SUNNICA ENERGY FARM

8.108 Applicant's Response to Other Parties' Deadline 7

Planning Inspectorate Scheme Reference	EN010106
Application Document Reference	EN010106/APP/8.96
Author	Sunnica Energy Farm Project Team

Version	Date	Status of Version
Rev 00	13 March 2023	Deadline 8 Submission

Drawing file: EN010106 / EN010106-001933-SEF_ES_6.3_Figure 8-2 Non-Statutory Sites.pdf

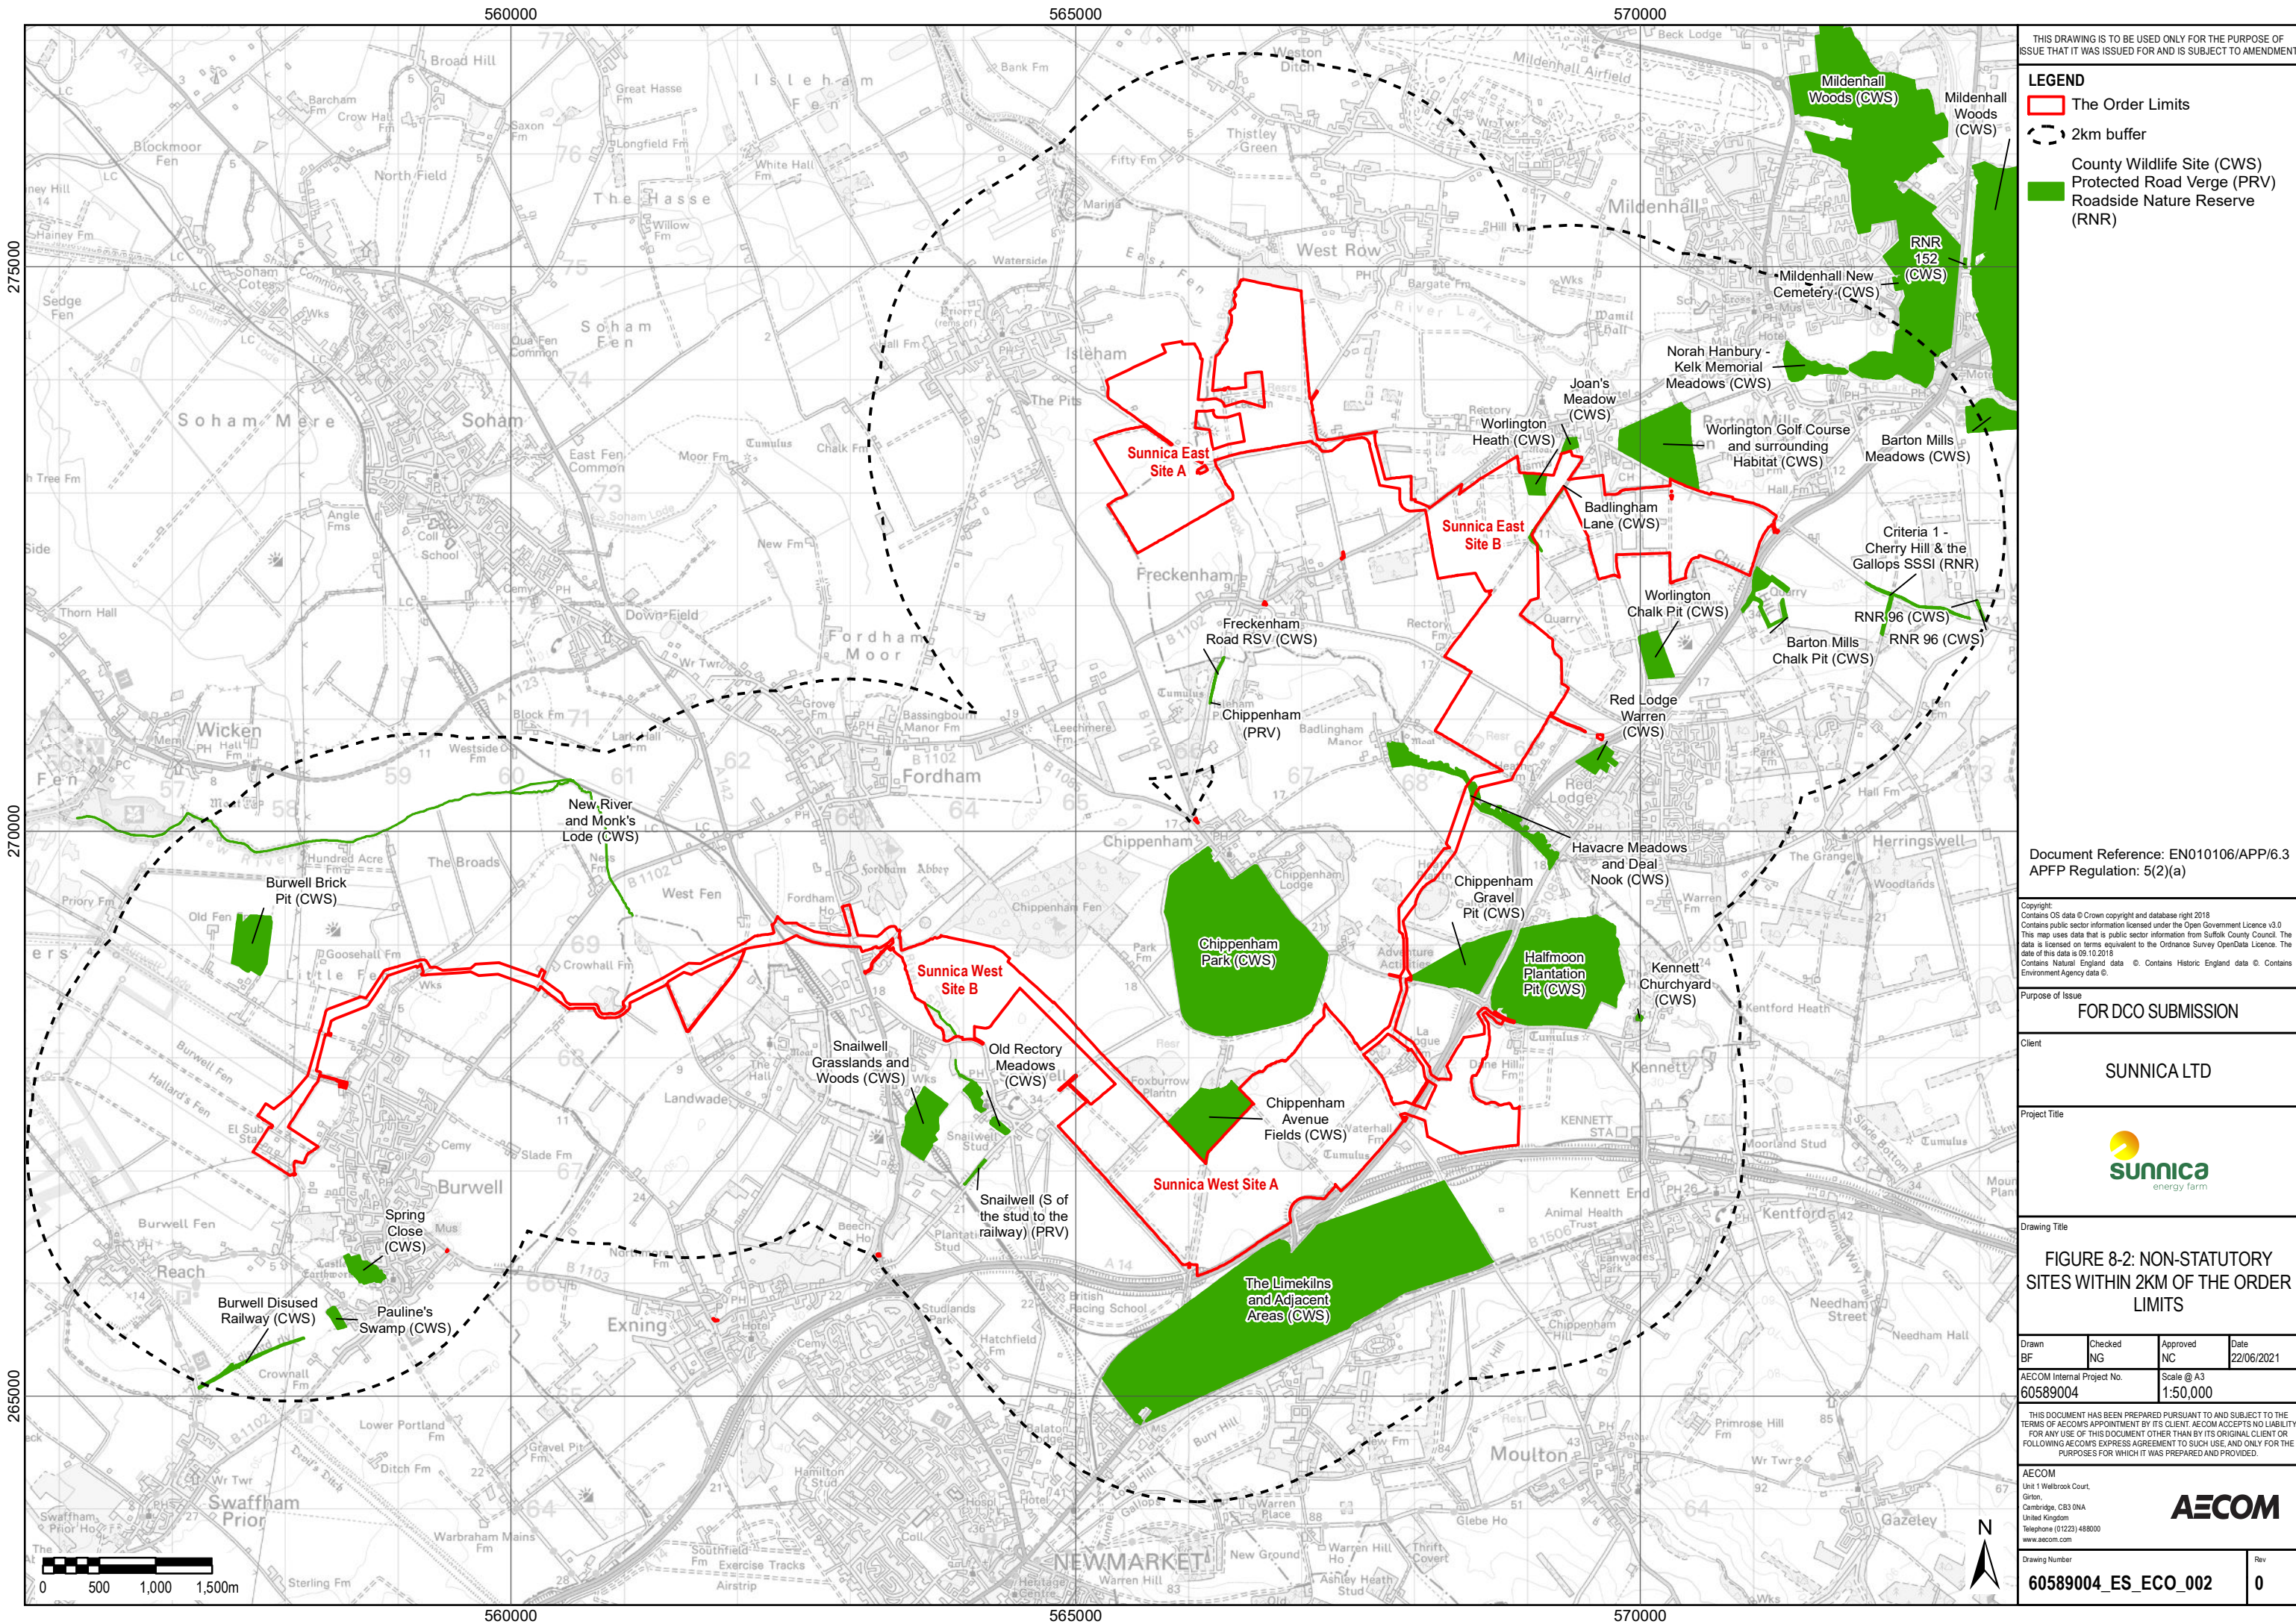
Say No to Sunnica Post Hearing Submission	SNTS note that the verges on Short Road, Snailwell, that are proposed to be used for access are 'protected	The location of Short Road Protected Road Verge remains intact and as such will not be impacted by the Scheme (6.3 Figure 8-2 Non-statutory sites within 2km of the Order limits [APP-186]). The

Topic	Document Ref	Summary of issue raised	Applicant's response
	Appendix C Paras 12-16 and Appendices 1 and 2	verges' for biodiversity purposed; and are concerned that the biodiversity impacts of the Scheme's access proposals have not considered that status.	Applicant does not consider that the use of HGVs on a road means that physical damage will necessarily occur to the verges.
Funding	Deadline 7 Say No To Sunnica Post hearing submissions	Lack of information provided in respect of viability and the application of the Vicarage Field. Adequacy of funding statement. Delay in the providing of the UK accounts.	<p>The Applicant has previously responded on the applicability of the Vicarage Field CPO decision at page 16 of the Applicant's Response to Other Parties' Deadline 2, 3 and 3A Submissions [REP4-037] and page 295 Applicant's response to Written Representations [REP3A-035]. Those submissions are not repeated.</p> <p>The Applicant is satisfied that the Funding Statement provides the level of detail required and is consistent with applicable guidance.</p> <p>The policy requirement in the DCLG Guidance (2013) is to demonstrate that "adequate funding is likely to be available within the statutory period" and that blight claims have been taken into account. The Applicant has clearly met those obligations. Major solar schemes are clearly capable of being funded, and there are multiple routes to that funding as identified in the Funding Statement. It is not part of the DCLG Guidance, or any wider principle relating to compulsory purchase, that a viability appraisal needs to be provided. That is because the fundamental question is whether there is a reasonable prospect of delivery of the scheme. There obviously is for the reasons already given. It does not need to be demonstrated that the Applicant has funding in place to deliver the scheme at the time of making the DCO. Rather, the question is whether such funding is likely to be available. For this reason, SNTS is wrong to suggest that there is an analogy to be drawn with the Vicarage Field CPO, where the scheme in question had been shown not to be viable and there was no clear evidence as to how that lack of viability would be overcome. In this case there is clear – and in</p>
